Recommendation Report for Planning Permission for Works or Extension to a Dwelling

REF NO: FG/7/26/HH

LOCATION: 2 Alderney Road
Ferring
BN12 5PJ

PROPOSAL: Proposed single storey extension.

DRAWING No.
Drawing 1
Existing & Proposed
Floor Plans & Elevations

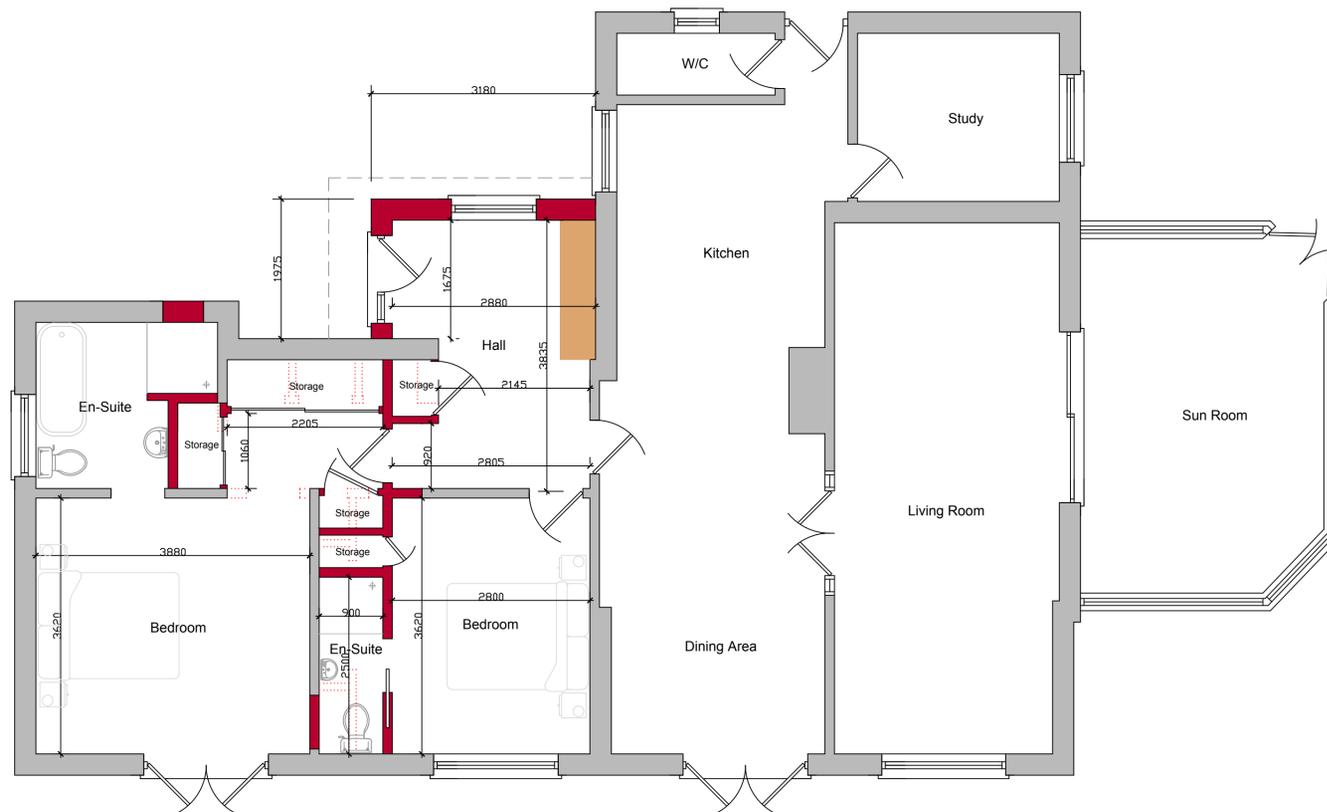
The extension would have a depth of 3.2m from the front (northern) elevation and 2m from the eastern flank elevation. The extension would have a frontage considerably less than 70% of the host dwelling and would be set in from the front and side elevations by 5m and 2.7m respectively, compliant with Arun Design Guide (ADG). Whilst the depth of the extension would exceed the 1.5m guidance depth for front extensions outlined within the ADG, the extension would remain set back from the front boundary of the application site by approximately 15.3m, and would be set back from the existing pitched roof projection. As, the proposed extension would not appear unduly prominent or incongruous within the street scene of Alderney Road.

The extension would have a crown roof, similar to the roof form found further south along the east elevation. The extension would be 3.8m in height, equal to the crown roof which currently serves the east elevation, appearing subservient to the host dwelling.

The relocation of the front door onto the front elevation, which fronts the highway, would provide the extension with a clearer frontage, while also improving surveillance. The proposal would be constructed from materials that would match those existing, ensuring the extension appears a logical addition.

The proposal would be equal in ridge height to the crown roof towards the rear and set in from the side boundary shared with 4 Alderney Road by approximately 4m. 4 Alderney Road has a bay window and French doors on the west elevation, which would look out onto the proposed extension at 2 Alderney Road. Given that the extension is set down from the ridge of the host dwelling, and the distance maintained between the extension and the western flank of 4 Alderney Road, the proposal would not result in any overbearing or overshadowing impacts.

The extension, being single storey, would not result in harm by way of overlooking; views from the extension would be of the driveway and frontage, both of which could be achieved currently.
